PLANNING APPLICATION NO: 3/2016/0974

Residential development, including the erection of 275 dwellings, a local neighbourhood centre, access arrangements and associated landscaping/wildlife infrastructure.

Land West of Preston Road, Longridge

Applicant Grimbaldston Farm Trustees and S and N Forshaw

X/JWPCLongridge.1/01 Rev E – Potential Site Access

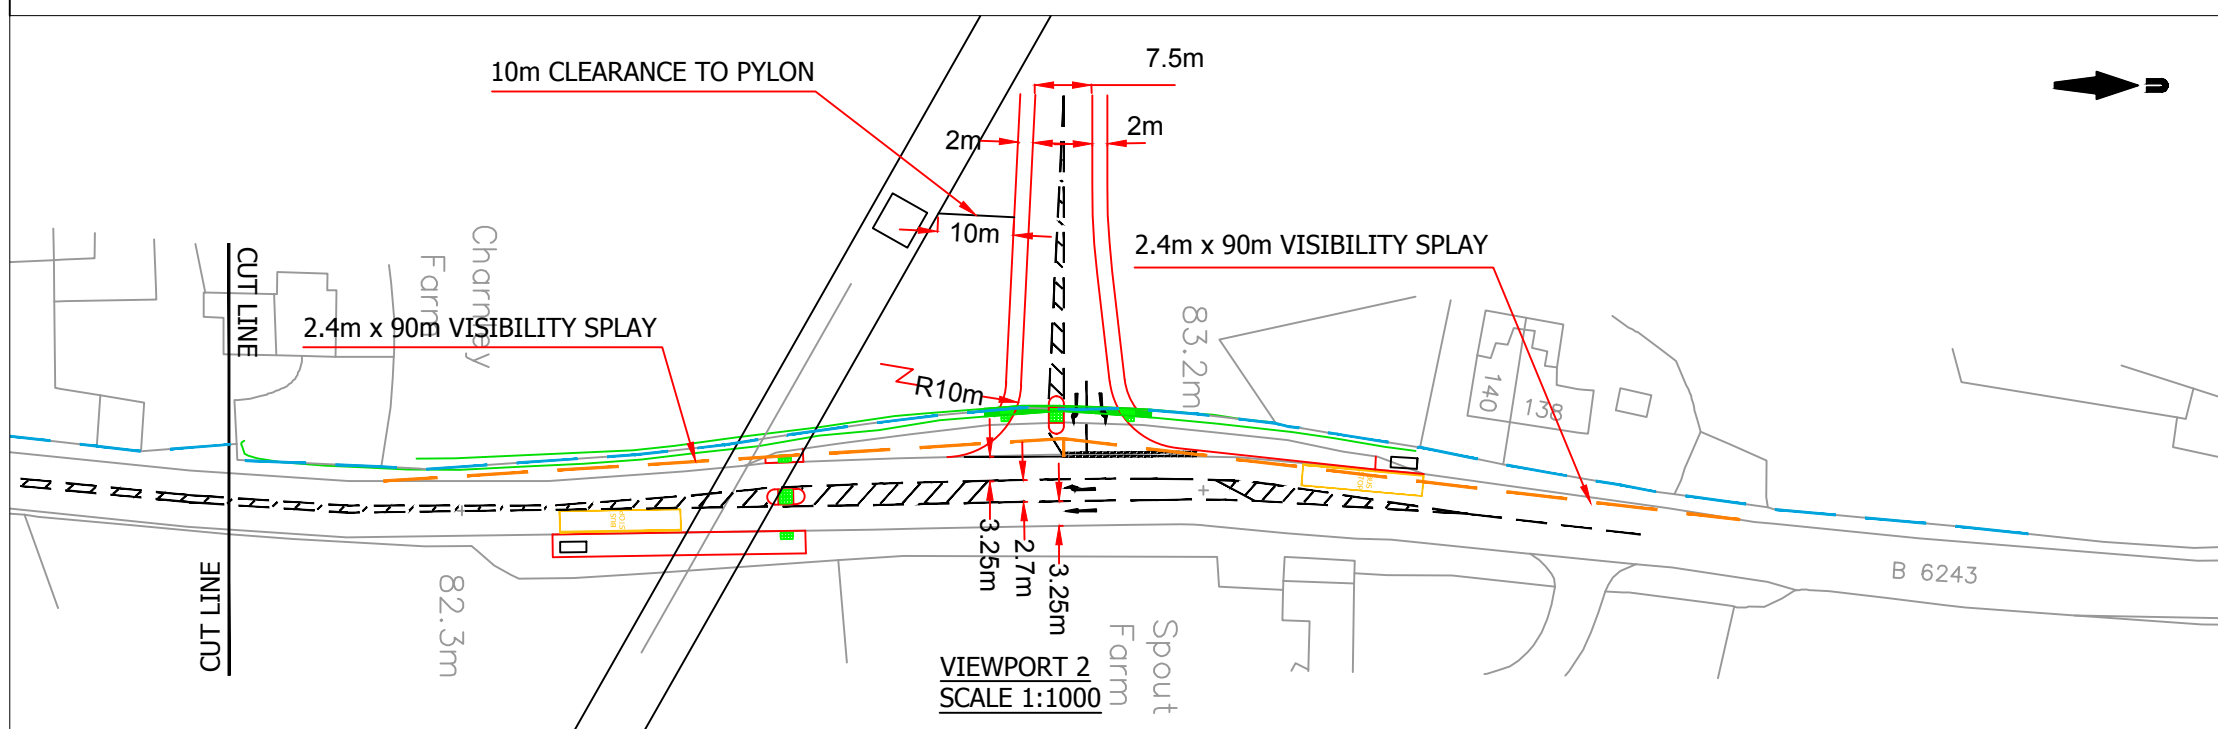
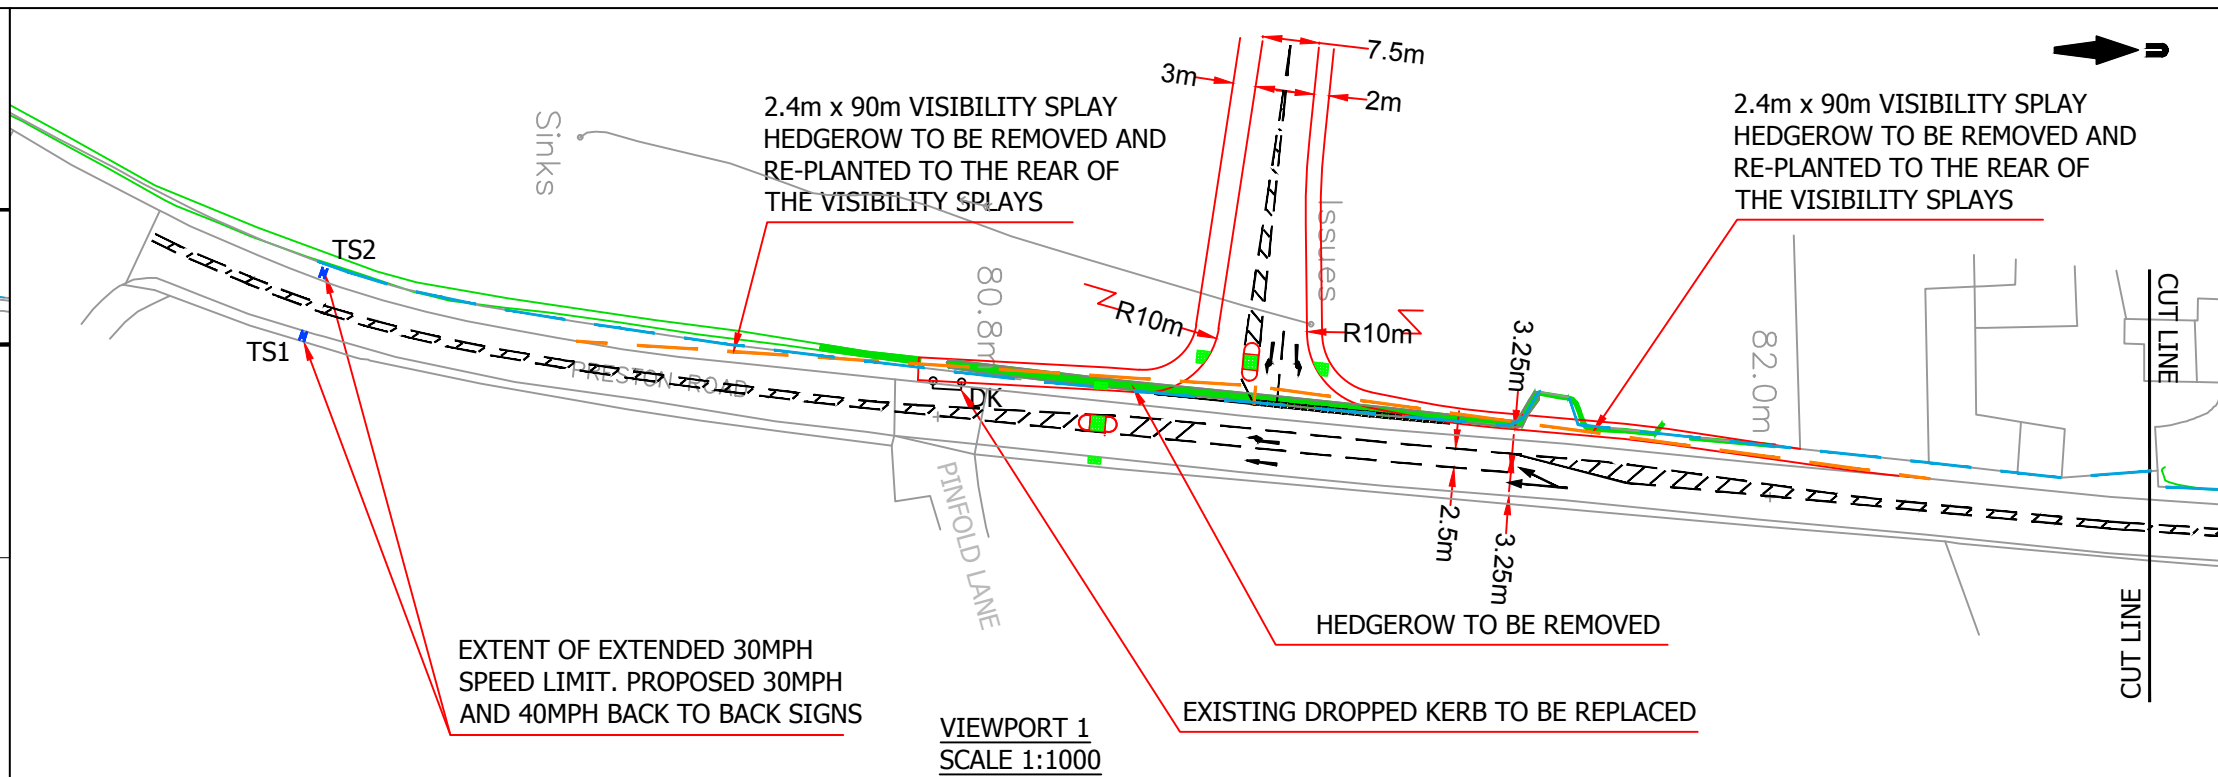
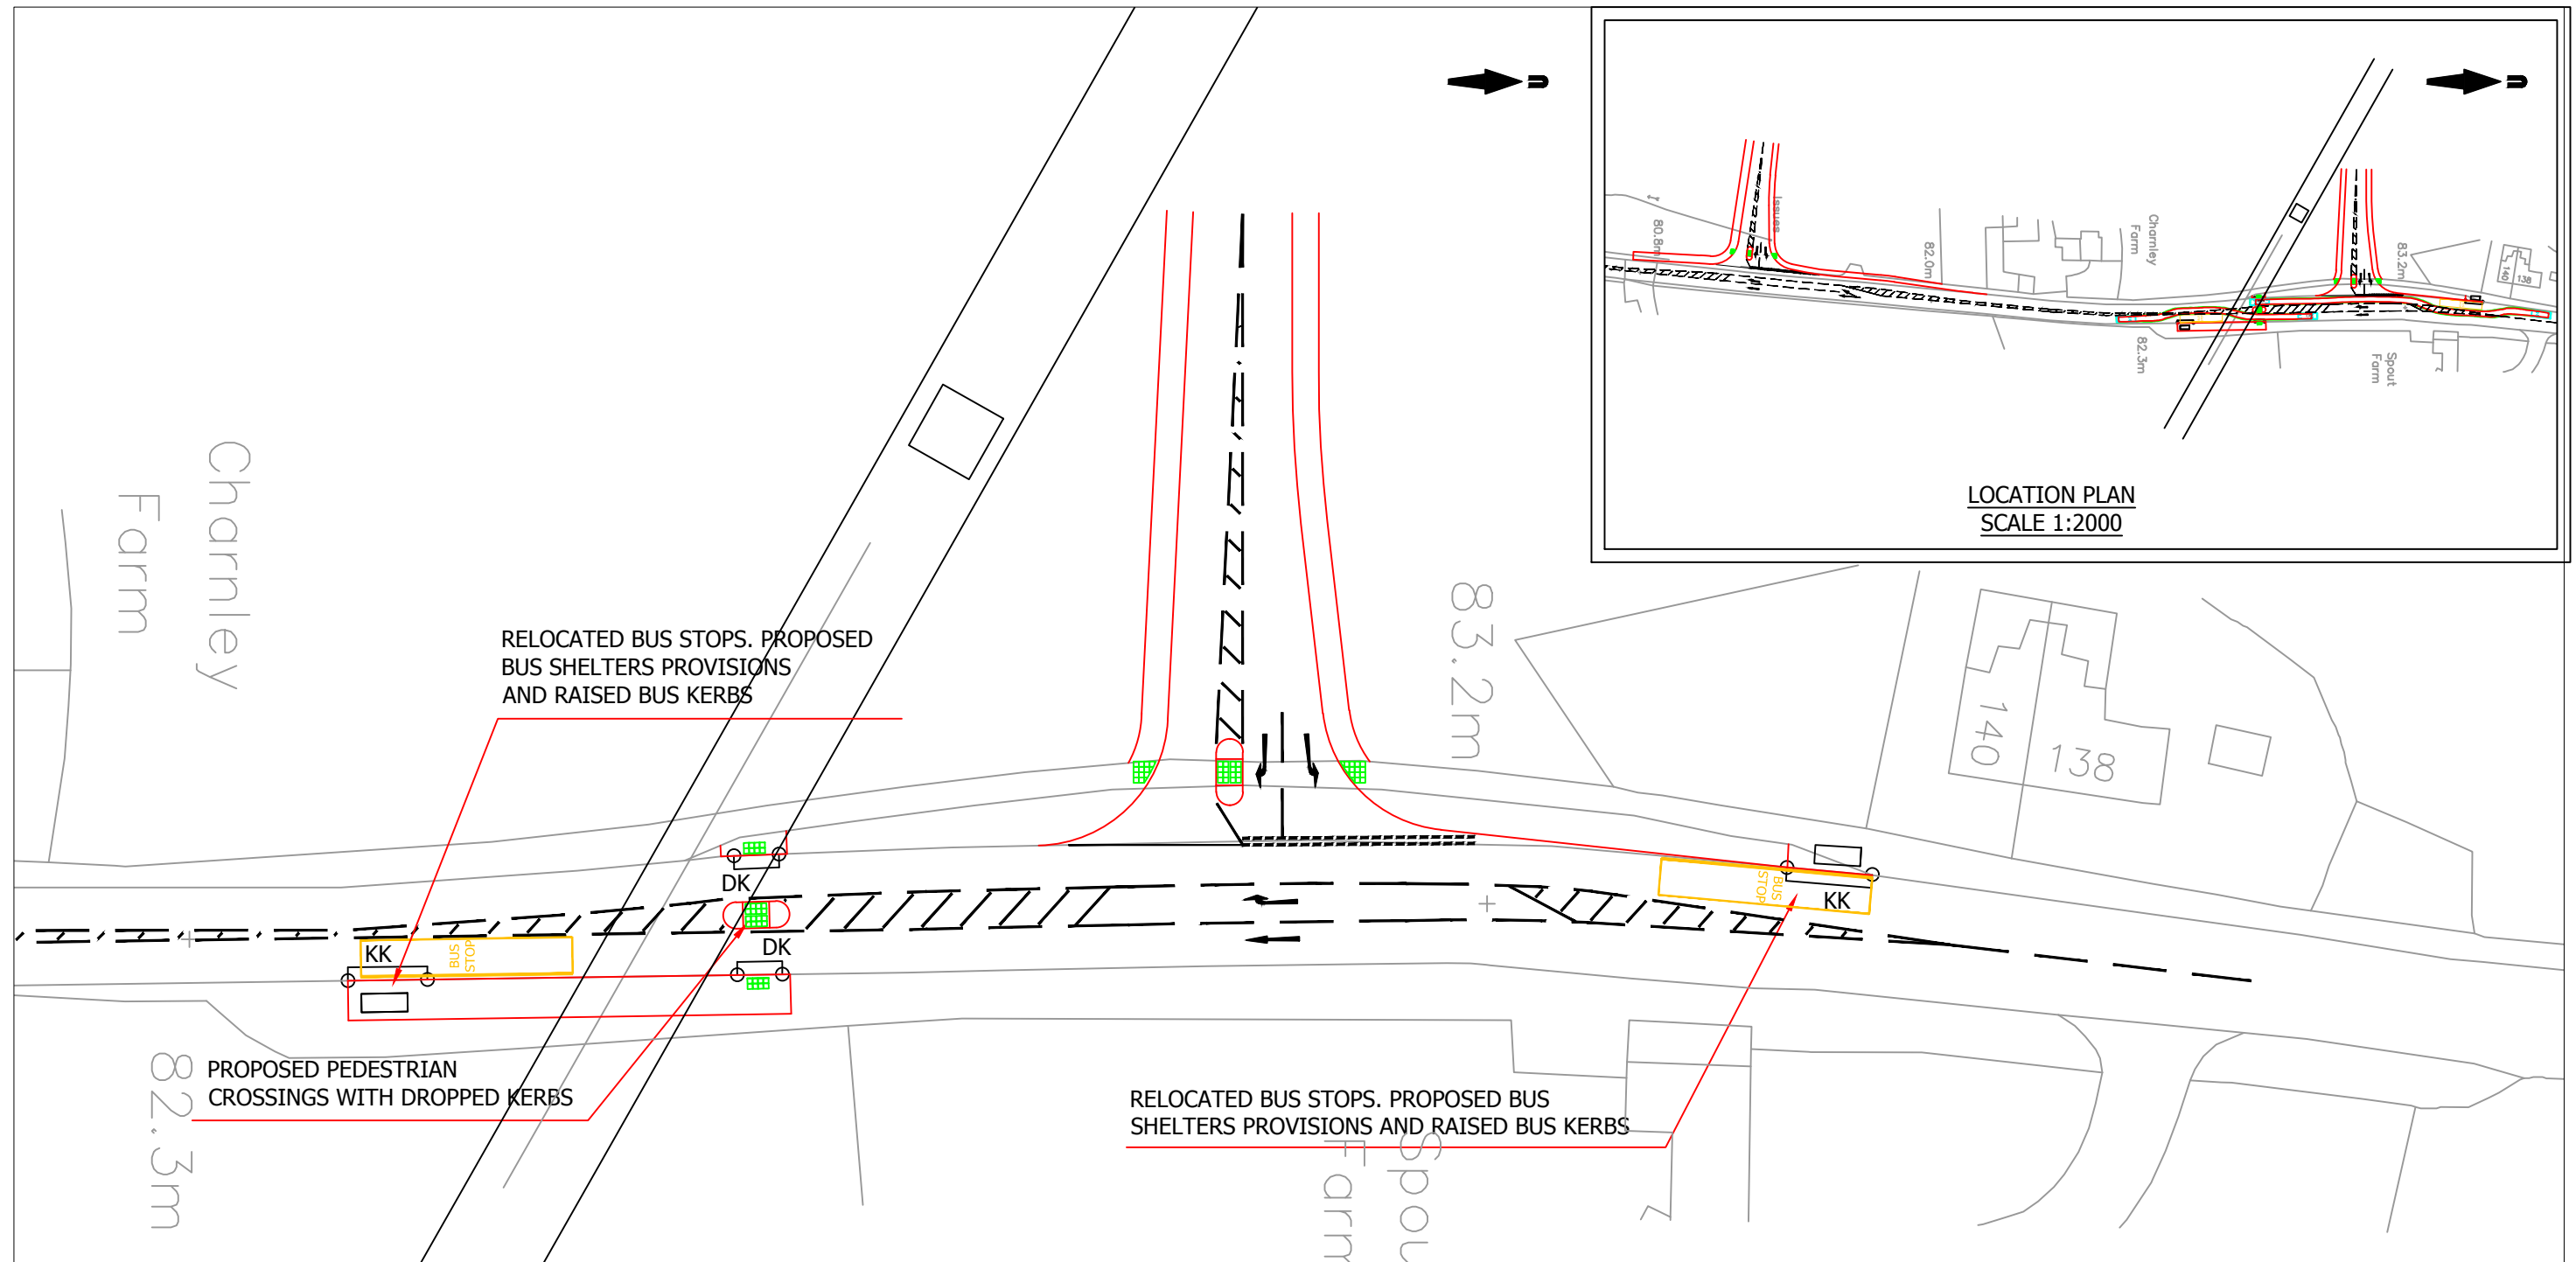
The applicant proposes all general vehicular traffic will access the site from Preston Road via 2 new priority junctions. An entrance to/from Water Meadows to the north will also be provided, although this would be restricted for use by emergency vehicles (if required), pedestrians and cyclists only. The proposed access junctions onto Preston Road are shown in drawing **X/JWPCLongridge.1/01 Rev E. Potential Site Access.**

The proposed vehicular access arrangements include 10m kerb radii, ghost right turn lanes, flare for two vehicles to exit the site and a pedestrian crossing island over the site access junction arms. The drawing also illustrates 2.4m x 90m visibility splays and associated existing hedgerows that will need to be removed/replanted to either provide the road widening for the junction, or set back to the rear of the vision splays.

The access roads are 7.5 m wide with 2m wide footways into the site on either side of each site access, with the most southern footway widened to 3m to enable use as a shared foot/cycleway. The 3m foot/cycleway has been continued along Preston Road, ending opposite Pinfold Lane where a dropped kerb will be provided.

The applicant is proposing a development site that will provide permeability by walking and cycling. Although the submission is outline at this stage the layout only includes token gestures to achieve this permeability; with a 3m foot/cycle route along the south access junction and indicated routes for cycle and footpath links. These proposals are not carried through the development layout, ie there are **indicative** cycle routes, but this is not supported with actual paved cycle routes as would be needed for cycling (unless routes will be "off road" route only suitable for mountain bikes). I accept that while the application is outline the indicative layout does not support the stated intentions for footpath and cycle routes. Further there appears no rational for the disjointed footway provision on the indicative layout and access drawing.

Further if the cycle route is to connect to Pinfold Lane then there should be detail for a suitable crossing point fully supportive of the cycle route and highway safety. A pedestrian refuge island would not be adequate for a cycle crossing.

The 2 proposed site access points meet applicable design standards and are capable of accommodating the development traffic movements and providing safe and adequate access for non-motorised residents. As submitted the proposed access points from Preston Road are acceptable as "in principle" drawings for planning purpose which will need to be detailed up to full construction drawings as part of any s278 agreement with the County Council for works in the public highway should the development be approved.

APPENDIX A: Proposed Site Layout

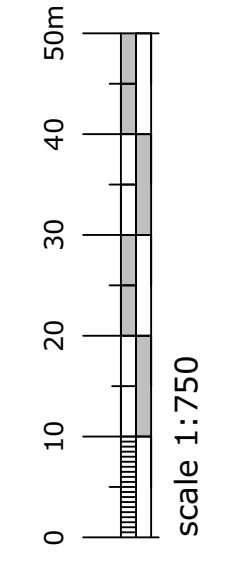
The indicative layout includes suggested links to the adjacent built environment (a footway to the site boundary and indicative line of a cycle route), to the existing playing fields to the west and a pedestrian route directly off Preston Road. The suggested links to the playing fields are not supported by the indicated layout infrastructure directly linking to the east and the main part of the site and neighbourhood centre. The scheme also indicates an indicative footpath link to the PROW (FP 107/108/109) that runs to the south west of the site. But again it is not supported within the site layout.

The developer has provided an indicative internal layout for the development, drawing number **10.192/05/R Indicative Site Layout**. However, the planning application is for outline with access only applied for at this stage, with internal layout subject to the reserved matters application. Notwithstanding, the developer should take note of general comment regarding the layout that have been made with regard to the access strategy and developer mitigation.

The submissions should provide continuous paved (and lit) routes internally linked to external infrastructure, with developer support funding for links outside the application site or, control of the applicant.
